# CITY OF ALBUQUERQUE

**RE: 2 Alikhani, Naser – Home  
1200 Hideaway Lane SE  
Grading and Drainage Plan  
Engineer's Stamp Date: 06/21/21  
Hydrology File: M23D017A**

Based upon the information provided in your submittal received 06/21/2021, the Grading & Drainage Plan **is not** approved for Building Permit and Grading Permit. The following comments need to be addressed for approval of the above referenced project:

ALIKHANI, NASER - GRADING & DRAINAGE PLAN

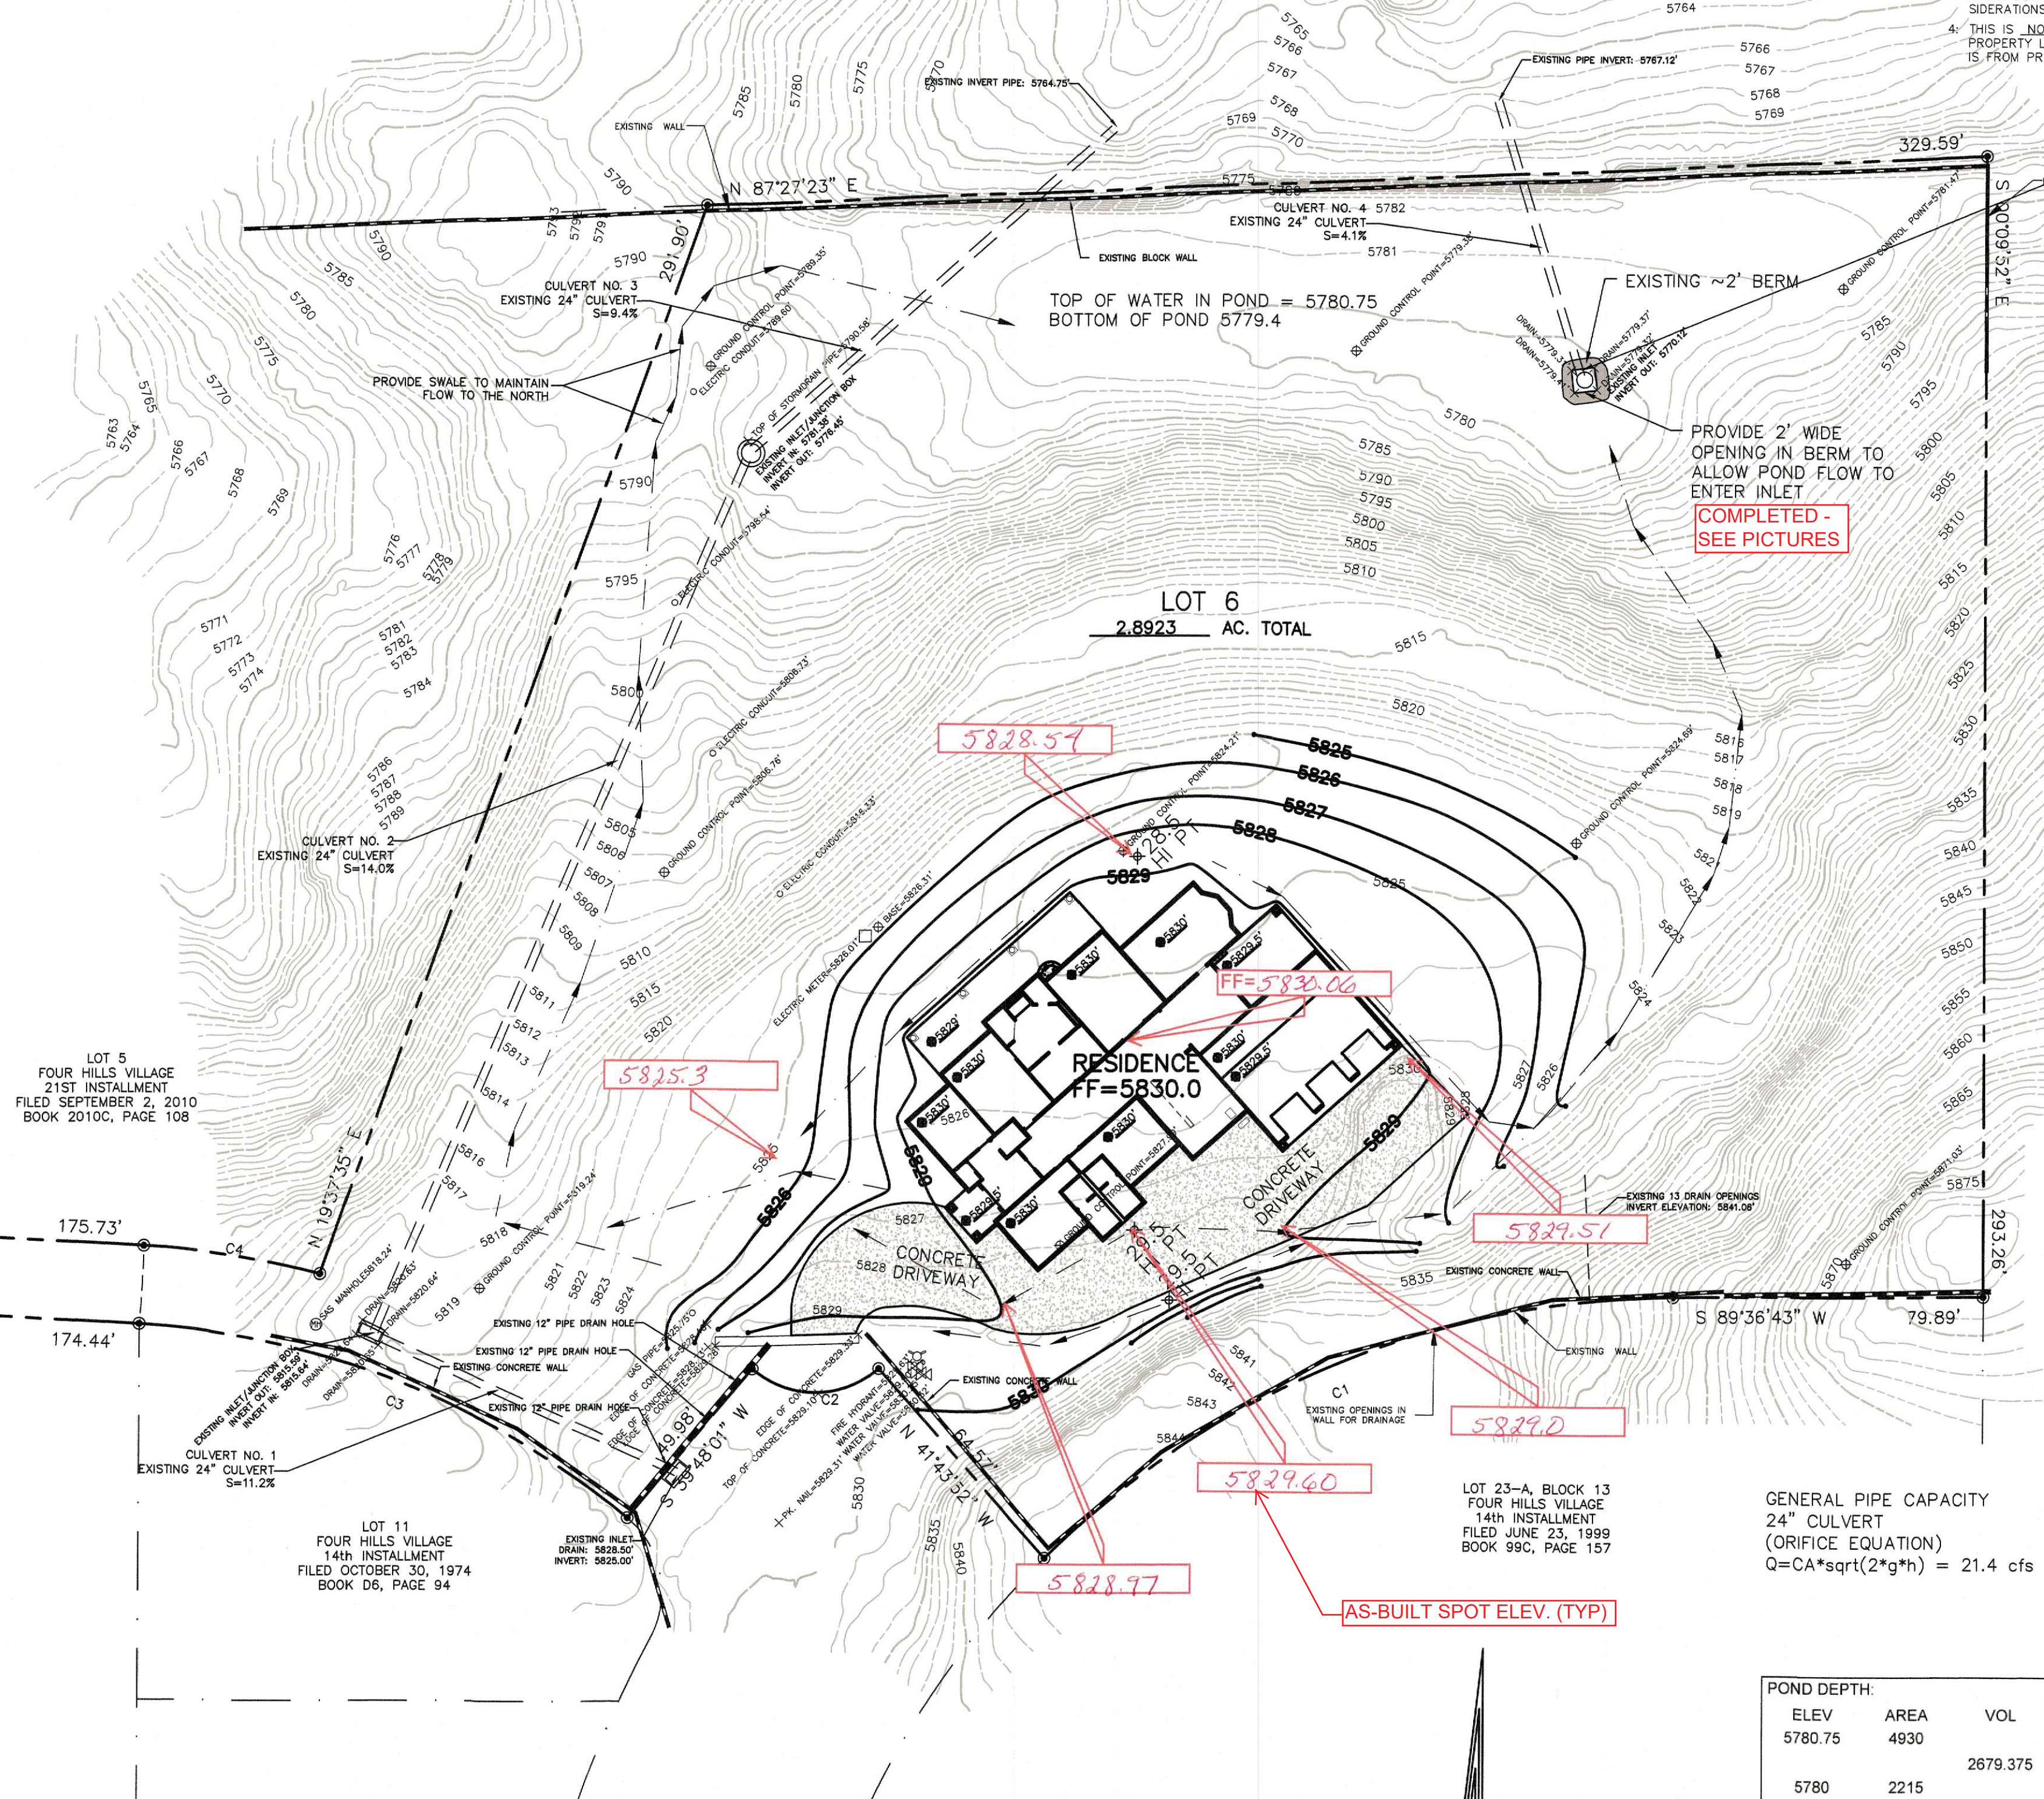
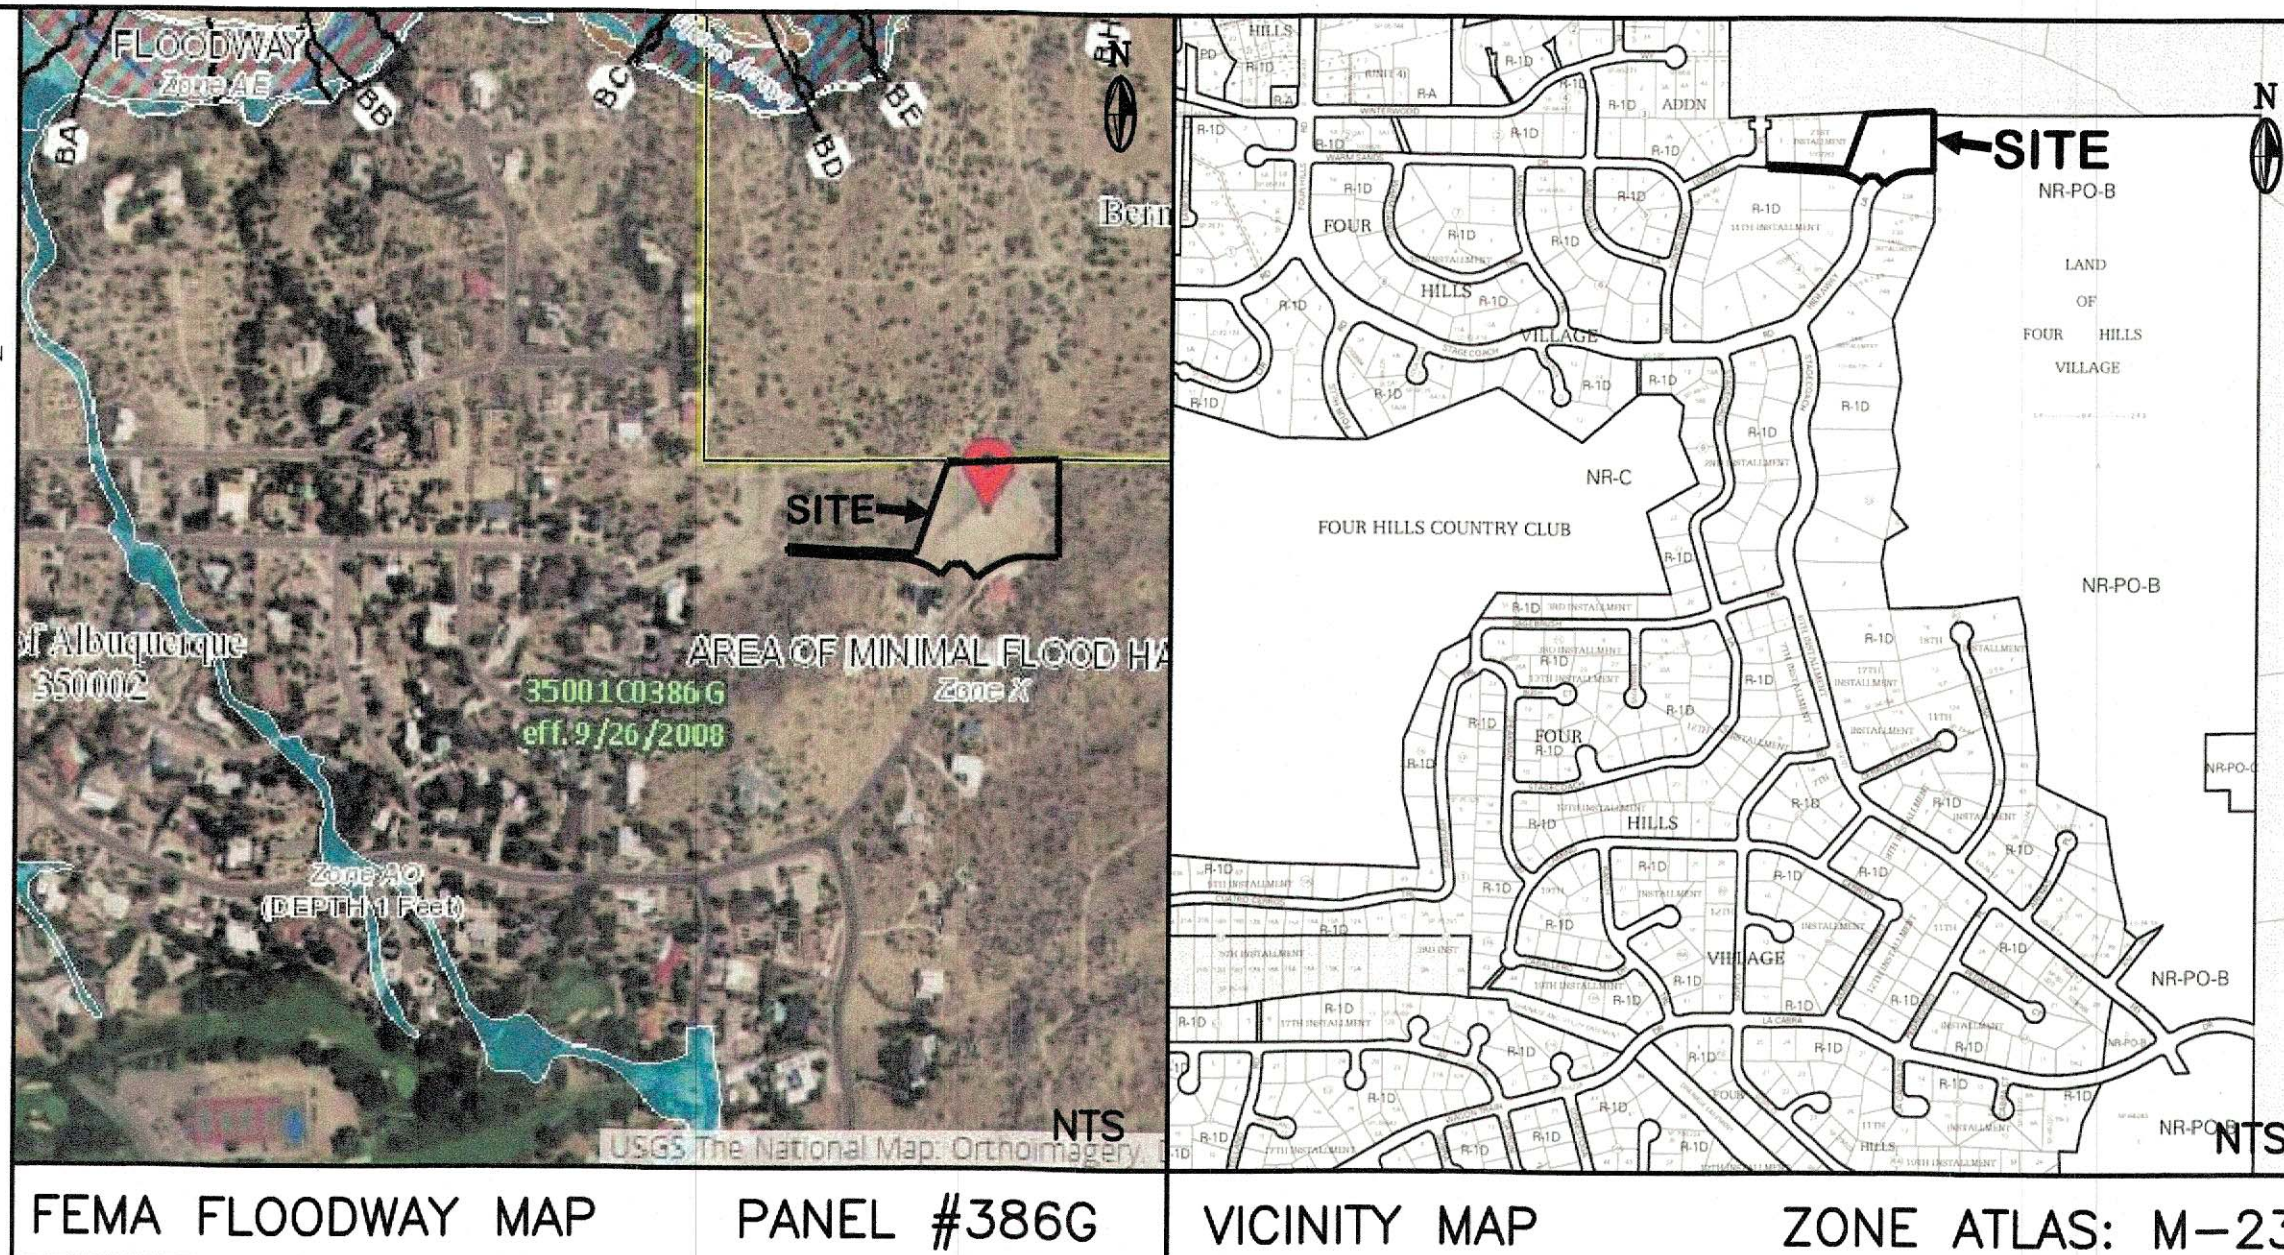
1. This lot is part of the Drainage Report for Four Hills Village 21<sup>st</sup> Installment by Bohannon Huston dated May 22, 2009 (M23D017). This drainage report states that each lot is required to pond developed flow greater than existing flow, so for lot 6 the existing flows is 9.62 cfs and that the lot is to discharge to the northeast as historic flow pattern. (see below).

A problem that I see is that a wall was illegally installed along the northern boundary of the lot sometime in 2010. The City does not have any records of the construction of the lot since a Grading & Drainage Plan would have been required to build it. This wall is currently impeding the historic flow pattern outlined in the approved Drainage Report. A solution will have to be created to resolve this issue.

2. Please size a detention pond as outlined in the approved Drainage Report and the existing pond that exists may have to be filled in.
3. According to the recorded plat for this subdivision, each lot Owner is required to provide an individual soils report from a Geotechnical Engineer for review and acceptance by the City of Albuquerque. This is very important since 2009 this lot Owner has been dumping earthwork onto this site so that the material currently there is not native to the site.
